From: Anita Gardner
Sent: 13 June 2018 09:07
To: Planning.Responses
Subject: FW: EP/52/18/PL

From: [REDACTED]
Sent: 07 June 2018 19:54
To: Neil Crowther
Cc: Anita Gardner
Subject: EP/52/18/PL

Objections & Responses: Lime Tree Close:

TITLE: Swept Paths March 2018 SITE: Limetree Close East Preston	Drawing: Vehicle Swept Paths	Autoturn Vehicle Swept Path Analysis & Visibility Data Prepared by Autoturn Specialists in Simulated Vehicle Swept Paths
	Drawing Reference: LT.SWEPT.001	
	Scale: On A2 1:200 / as bar

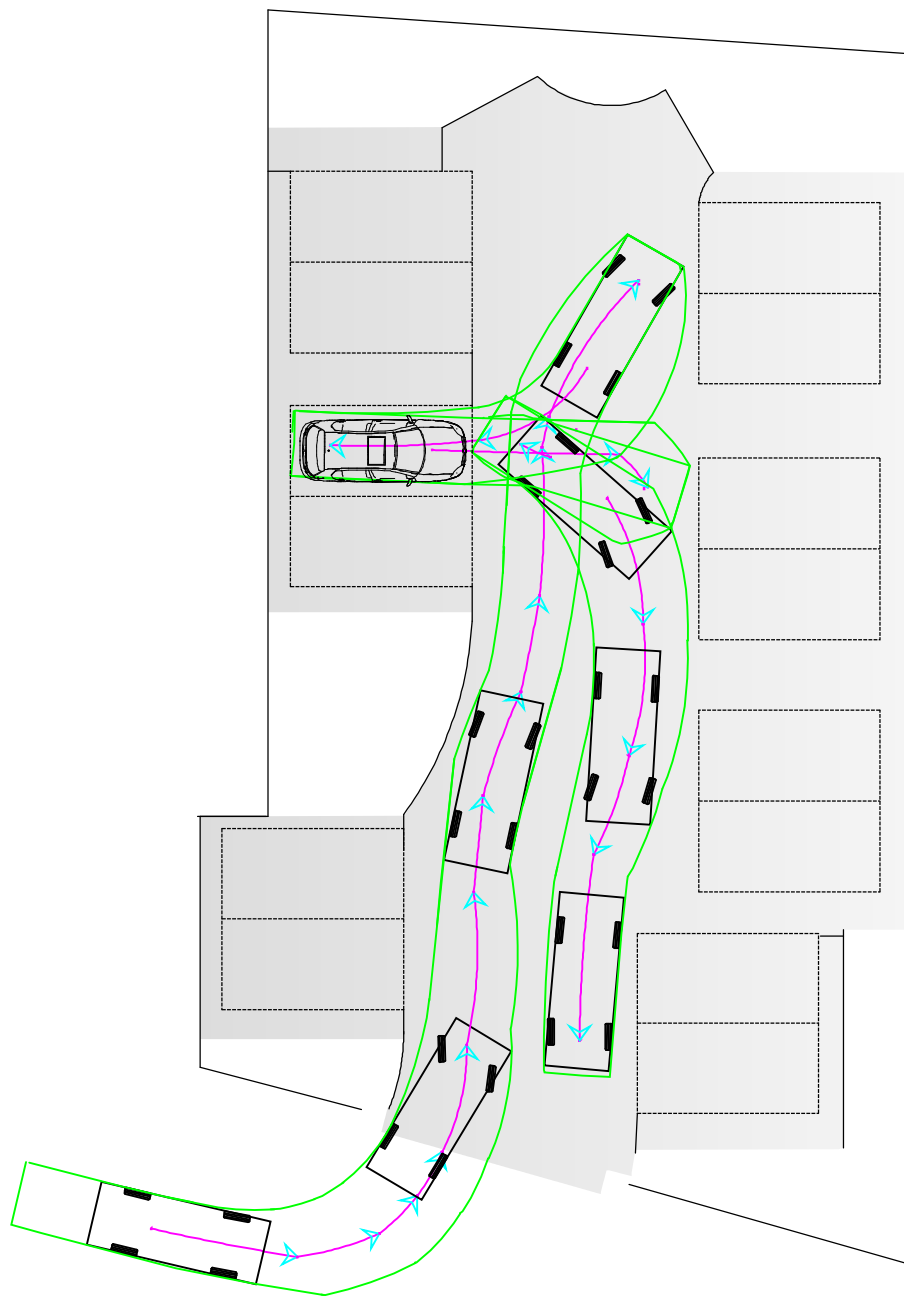
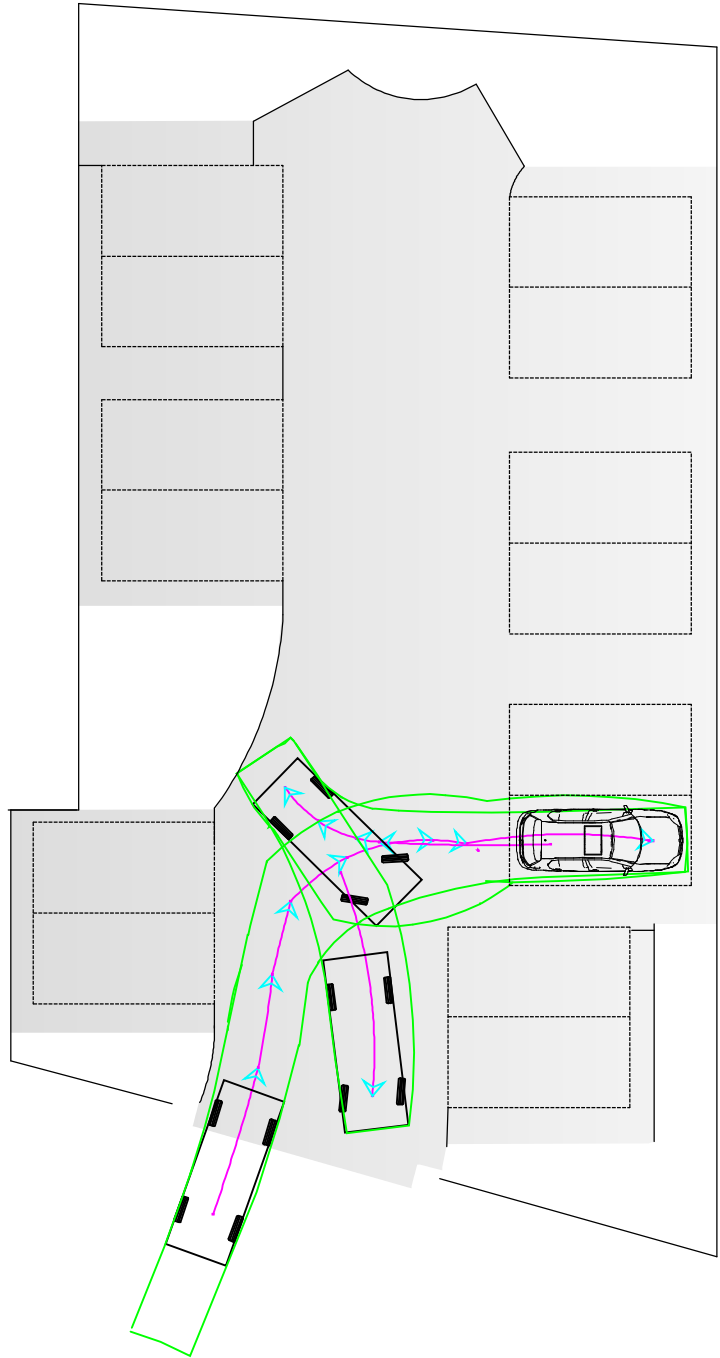
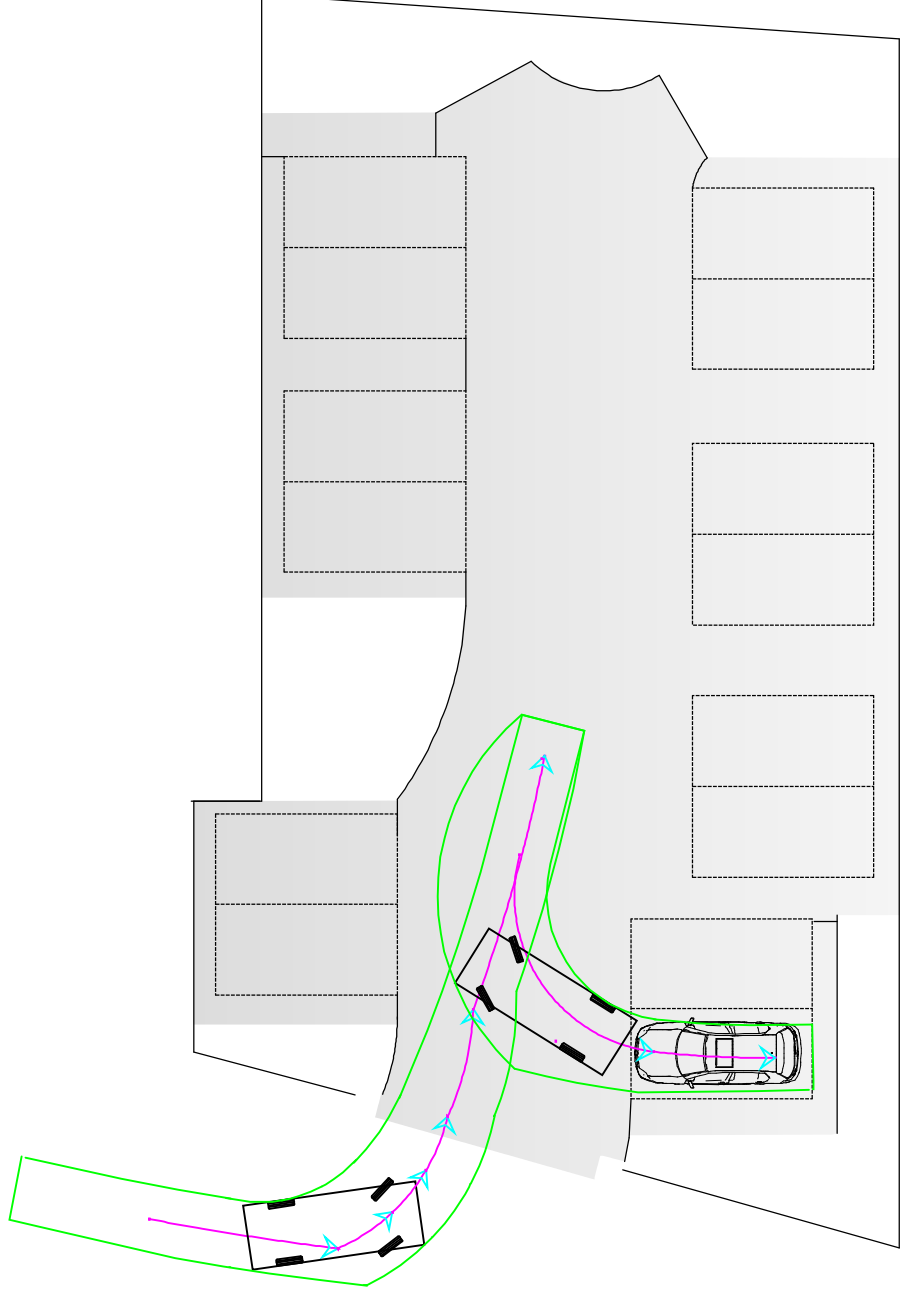
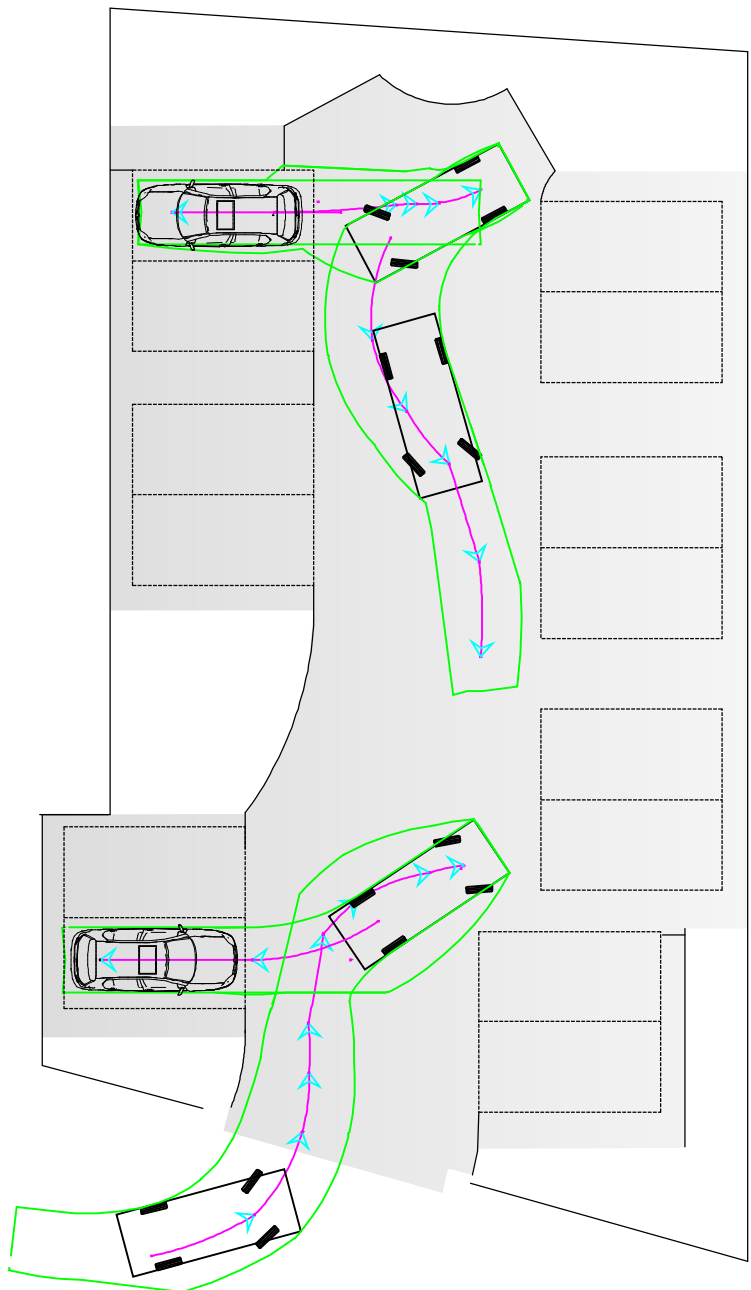
The pictures submitted are not inconsiderate parking, they are every day parking issues that we reside with. Thus demonstrating that Lime Tree Close is already under a huge amount of pressure from heavier traffic than it was built for in the 1970's. If the comments are in respect of emergency vehicles, then I think we all agree that in an emergency the vehicle needs to reach the person in need fast and safely and sometimes is parked inconveniently, but that is they these vehicles must operate.

The photographs submitted of the large commercial vehicles, in complete contrast to the comments made above, are in fact demonstrating clearly simply how far a large commercial vehicle can actually drive safely in to LTC. Each time the vehicle has to stop exactly where the proposed entrance to the new development is suggested to be as it cannot proceed any further. Not only would this cause obstruction and delay for people arriving and exiting both the proposed new development and LTC. It also would be a safety hazard for the residents of the proposed new development, especially as there is no provision for a footpath.

In response to the last comment of the above paragraph. The plans for the proposed development appears to be minimal parking for the sized houses. This would not allow sufficient space should one or more of the residents have a works van that they bring home, or a larger vehicle than a modern compact car. The planned space certainly does not safely allow for large commercial vehicles to access the proposed development and could be a huge safety hazard to anyone arriving or leaving the proposed development on foot, bicycle or with a pushchair. Resulting in the likelihood that vehicles would drive in to LTC. Abandon their vehicle while they make a delivery or attend an appointment in the proposed new development. This has a direct negative impact on the residents of LTC.

Using the West Sussex County Council parking demand calculator (left fig 3.) the proposed new development will require a total of 12 spaces, by providing 14 within the site requirements are exceeded. The parking has been laid out to allow for interspersed planting areas having a large range of shrubs, six specimen trees and a small area of grass.

No turning or manoeuvring will be required on Lime Tree Close as sufficient space has been allocated within the site for turning, passing and the space has the capacity to hold several vehicles in transit. The swept path analysis demonstrates this.
